Ref: SSD-82395459

RE: SUBMISSION TO SSD-82395459 at Nos. 3A, 3B, 5A and 7 Burgoyne Street, Nos. 1 and 3 Pearson Avenue and No. 4 Burgoyne Lane, Gordon

ATTACHMENT 1

Ku-ring-gai Council's objection to SSD- 82395459 at Nos. 3A, 3B, 5A and 7 Burgoyne Street, Nos. 1 and 3 Pearson Avenue and No. 4 Burgoyne Lane, Gordon

DRAWING TITLE
HEIGHT LIMIT PLANE DIAGRAM

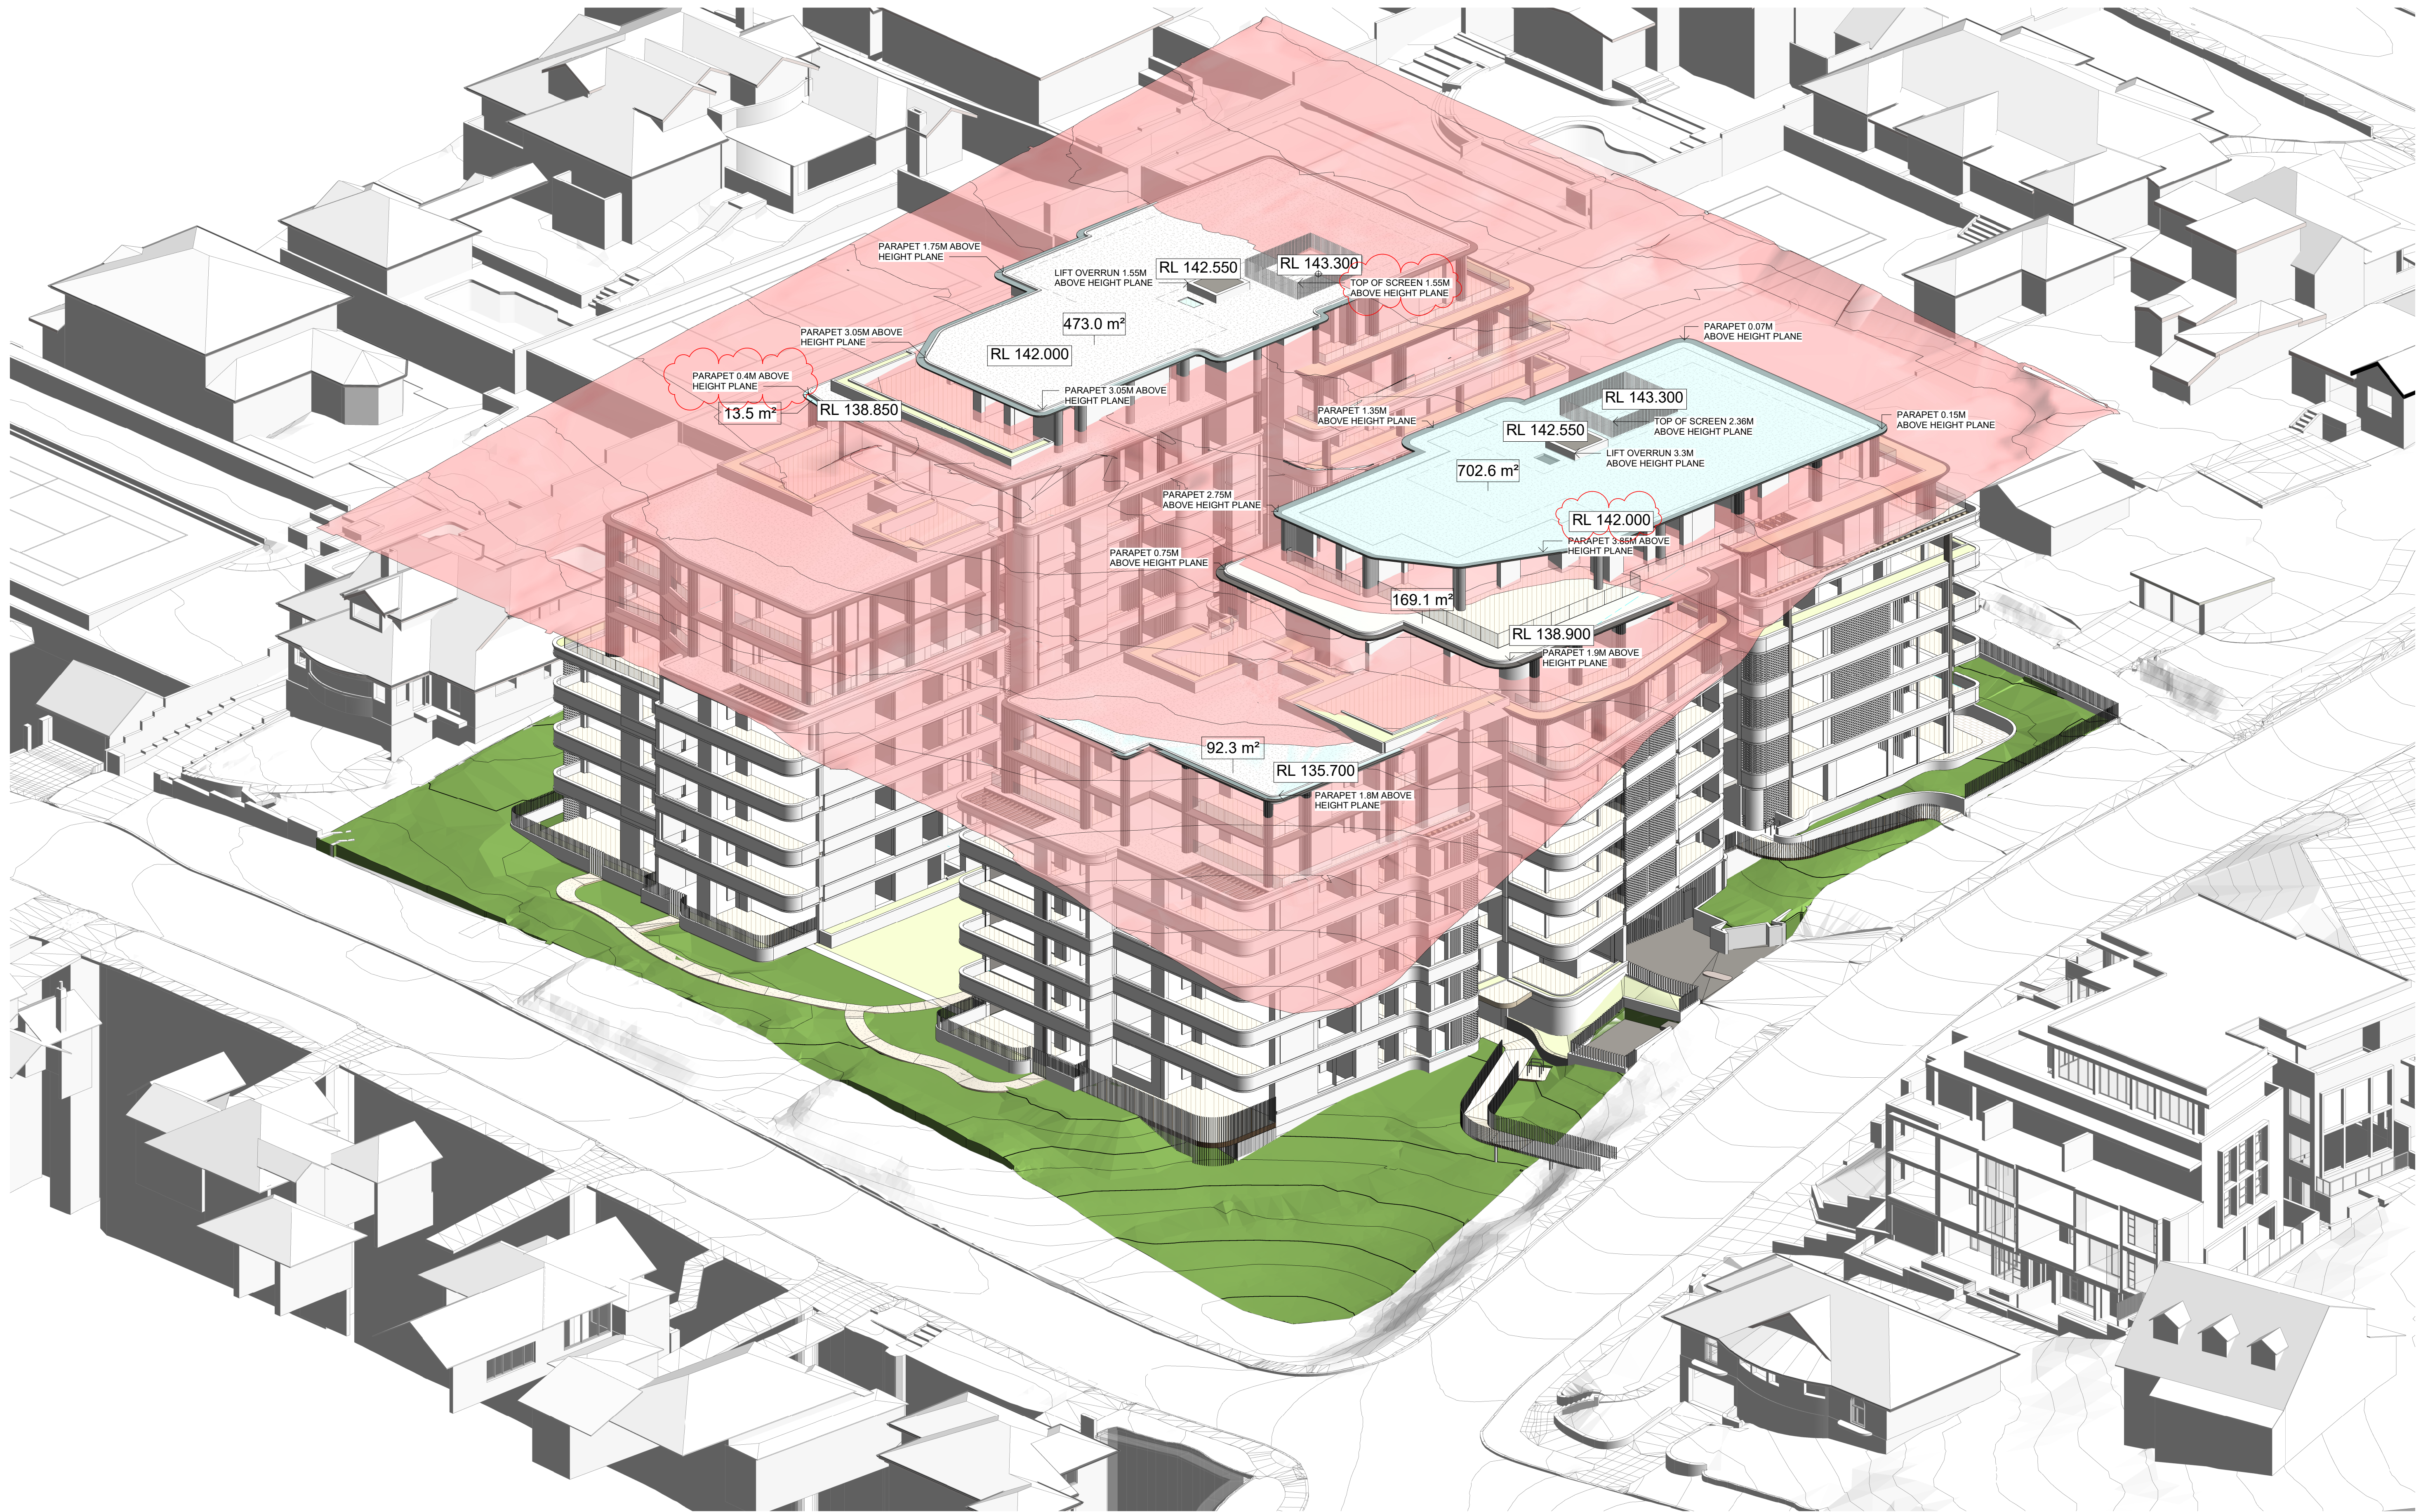
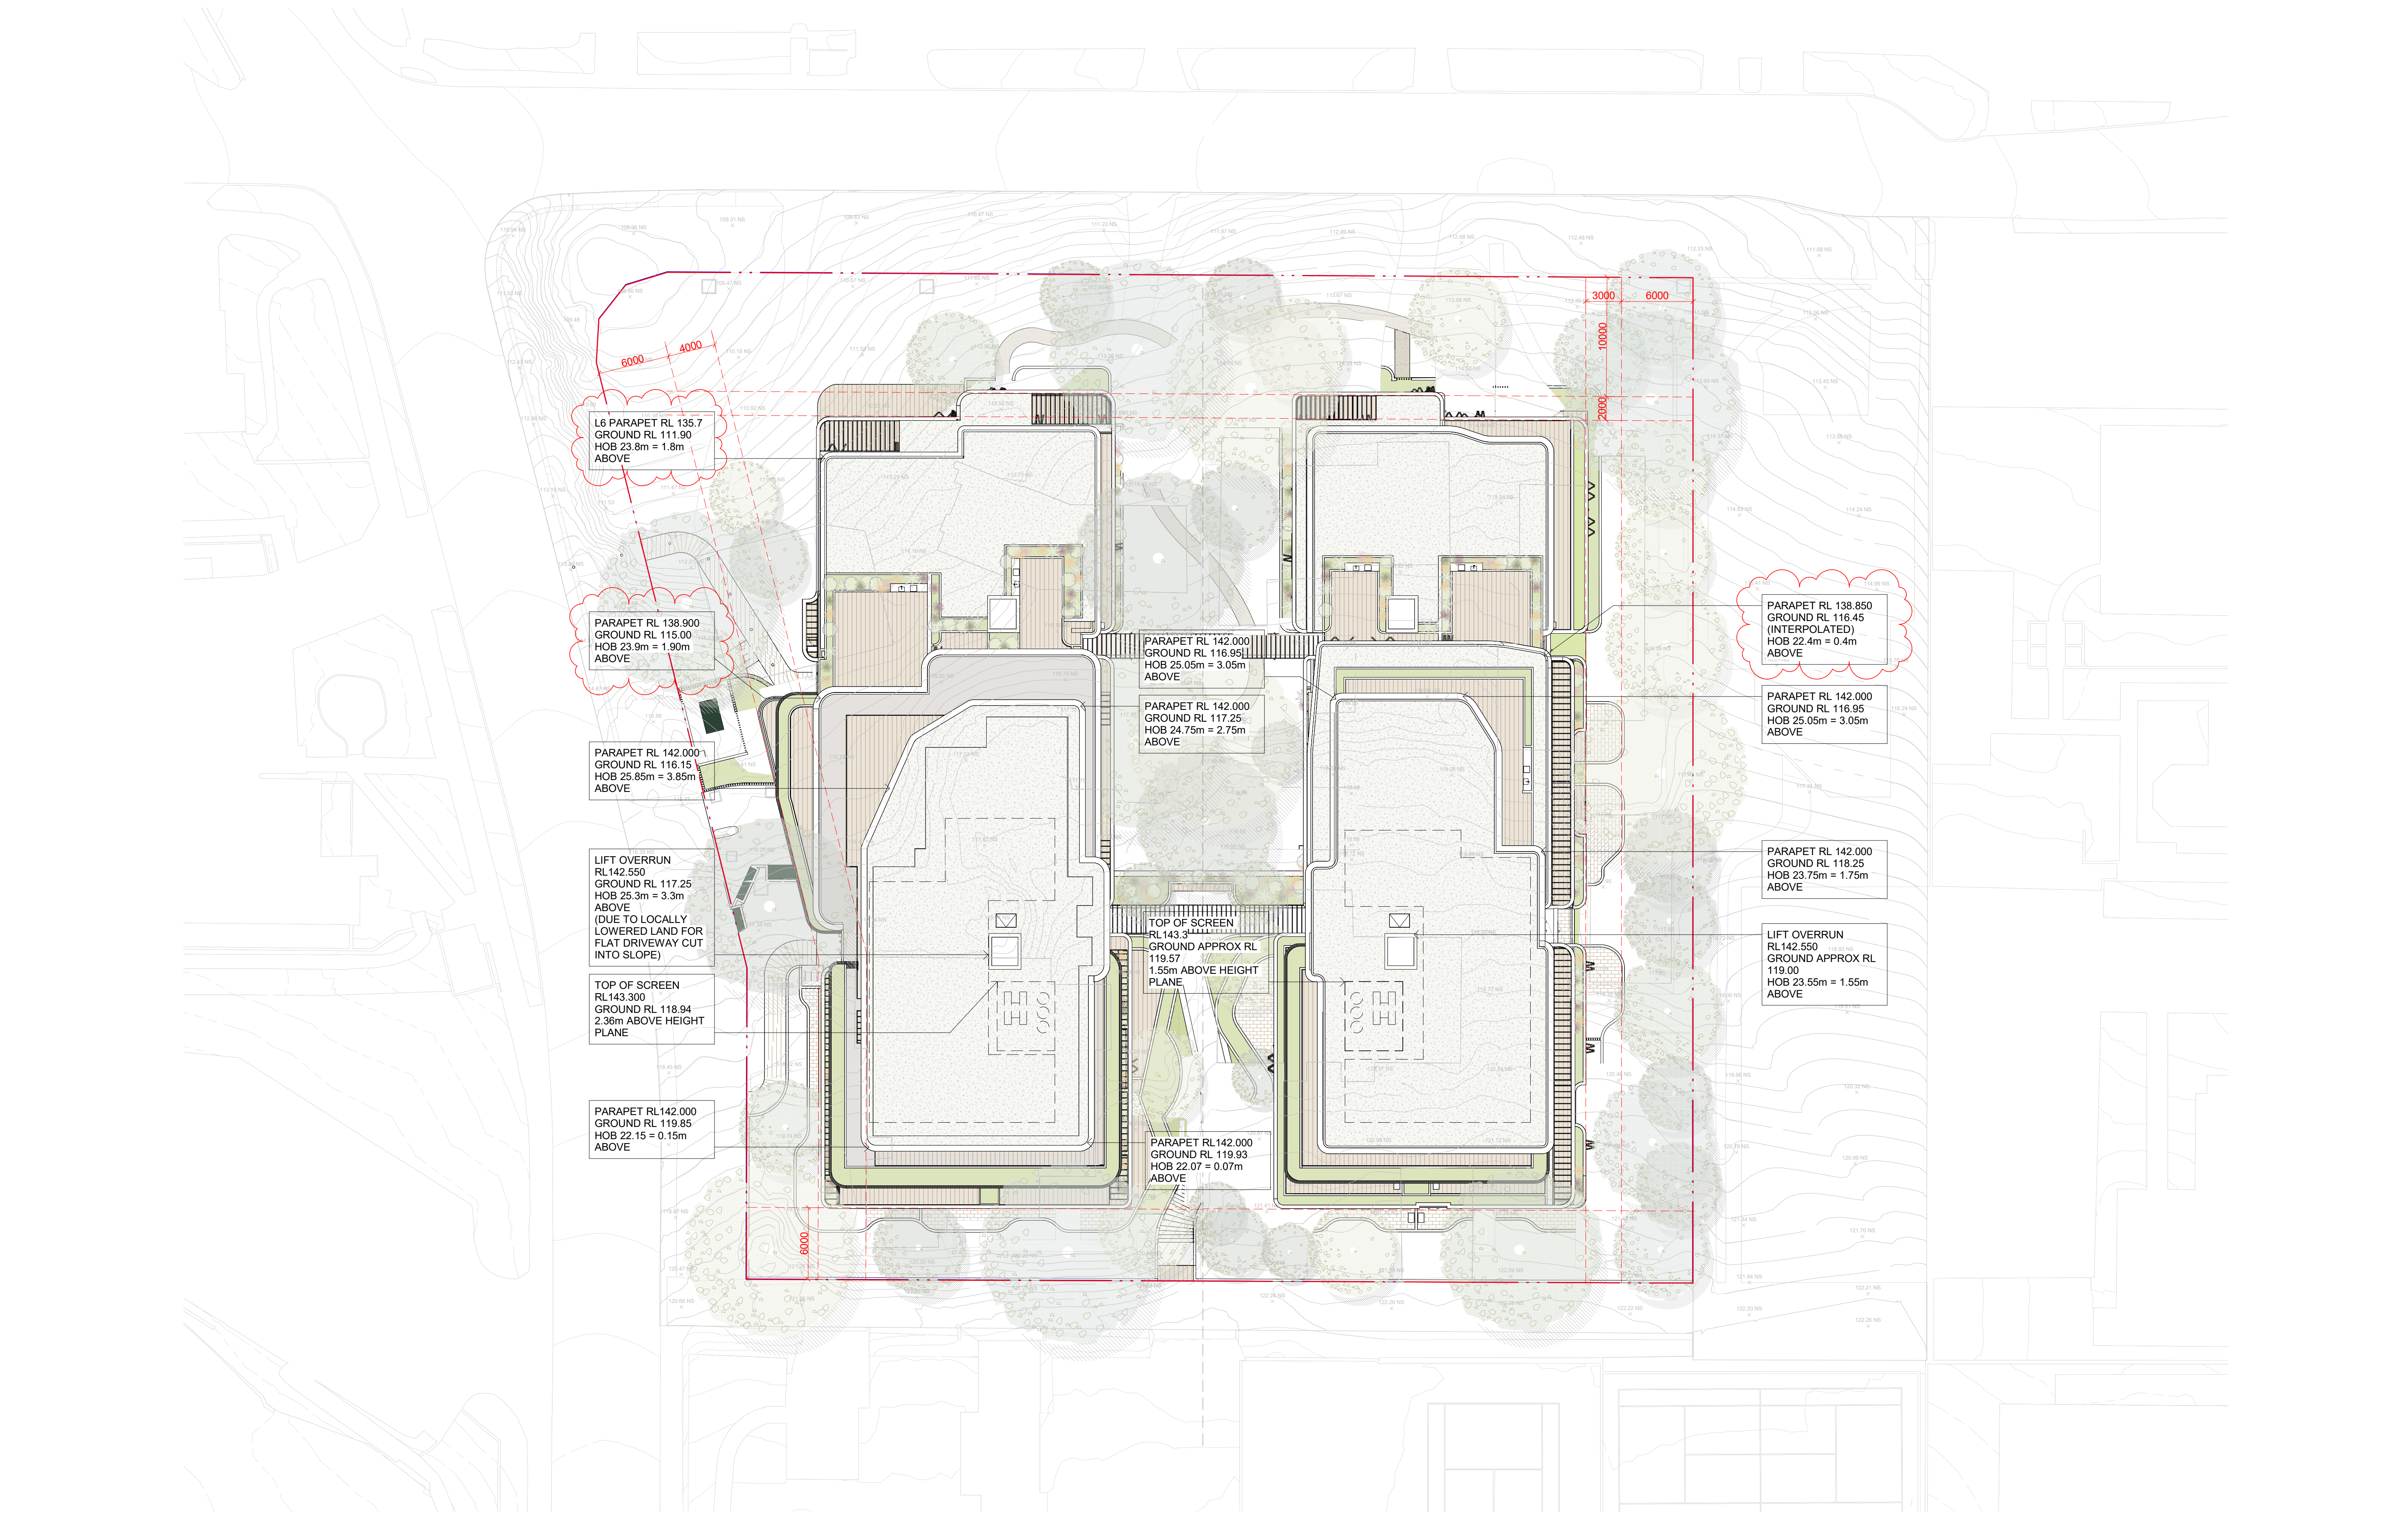
The permissible height limit is NOT shown on any of the street or internal elevations so height exceedances are difficult to ascertain. Reference to Architectural plans DA4.03 Site Sections 5 and 6 show that the height exceedance is most apparent on Building A. The whole floorplate of Level 7 and a part of Level 6 would appear to exceed the height limit.

As noted above, the proposed building height is difficult to verify from the documentation provided. Amended elevations clearly showing the height variation should be provided, and a site plan overlaying existing ground levels should also be provided.
